A66 Trans-Pennine Project Scheme 0102 – M6 Junction 40 to Kemplay Bank

This is a Written Representation on behalf of Penrith Properties Limited in respect of the proposed acquisition of land identified in Developer's Application Document 5.13 as Plot 0102-01-20 and described in the book of reference as:

Permanent acquisition of 1258 square metres of commercial premises and hardstanding known as Environment Agency, Ghyll Mount, Gillan Way, Penrith 40 Business Park, Penrith CA11 9BP (CU138344 – Absolute Freehold) (CU137635 – Absolute Leasehold).

Drawing Title
Land Plans
Regulation 5(2)(i)
Sheet 1 of 2

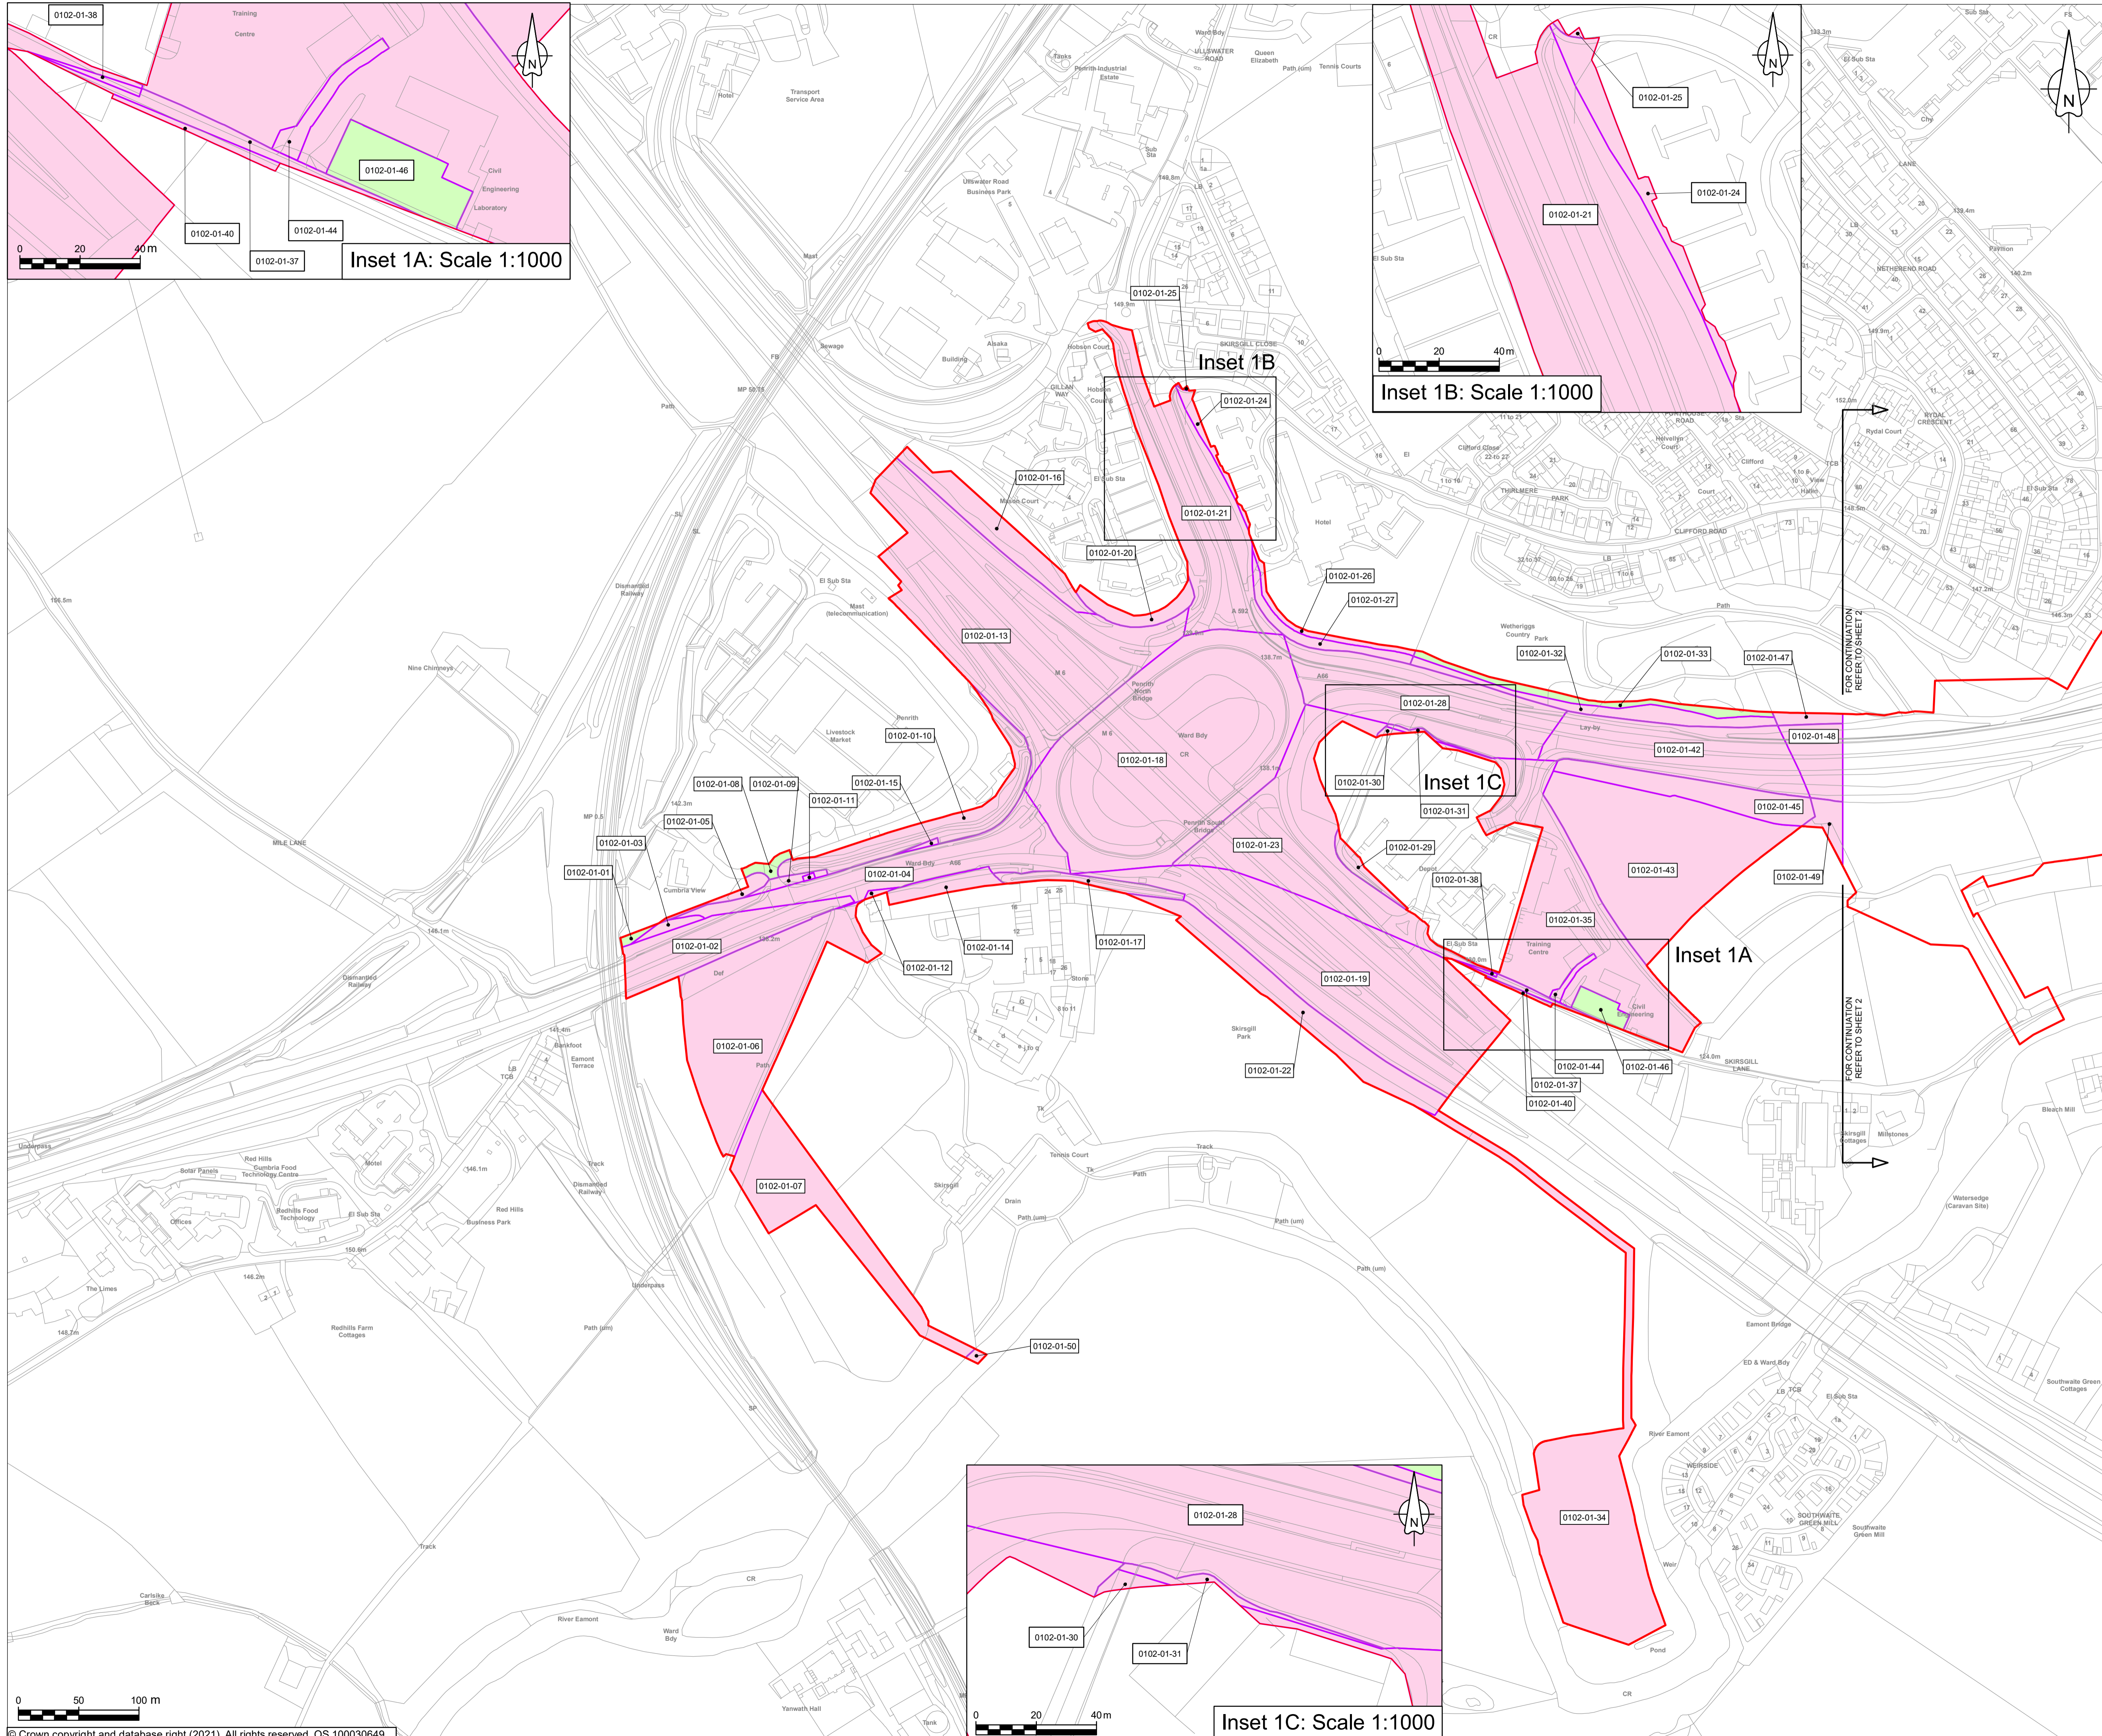
The extent of the land to be permanently acquired takes the boundary between PPL's ownership with the existing highways land from the bottom of the landscaped slope to the top of the landscaped slope and includes all the tree planting that forms a natural screen for the building.

The extent of proposed works that relate to Plot 1020-01-20 are set out the Applicants document 2.5 General Arrangement Drawings indicating the extent of proposed works on the plot including proposed cutting, embankment, realignment and widening of the shared cycleway and formation of verge. It is noted that on the drawing it shows that the Police Observation platform is to be retained in its current position.

There are no sections provided by the Applicant in relation to the proposed works that affect plot 0102-10-20 that demonstrate the extent of the proposed changes to the existing levels/profile of the land within plot 0102-01-20.

The verge widths noted on various sections in scheme 0102 vary from approximately 1m to 4m excluding any additional land required for either an embankment or a cutting. The area of verge required that impacts on plot 0102-01-20 appears to be in excess of 4m, and up to 10m in some parts.

The extent of land required in in excess of that required to configure an appropriate width for a shared cycleway or road user visibility, given the location of the police patrol platform which is not being repositioned and the proposed planting regime on the land to be acquired.

The proposal scheme appears to either remove the existing maturing broadleaf trees already in place and replant with broadleaf trees or leaving the existing broadleaf planting in place. Since no proposed works are identified within the majority of plot 0102-01-20 it is likely that existing established planting will be retained and therefore there is no need to permanently acquire the land.

PPL do not believe the land identifies as plot 0102-10-20 is required to enable the scheme be delivered for the reasons stated however in so far as it is strictly necessary for the scheme PPL would enable access by agreement to the land to carry out the works on the strict proviso that it is reinstated with an appropriate boundary treatment in its existing location.
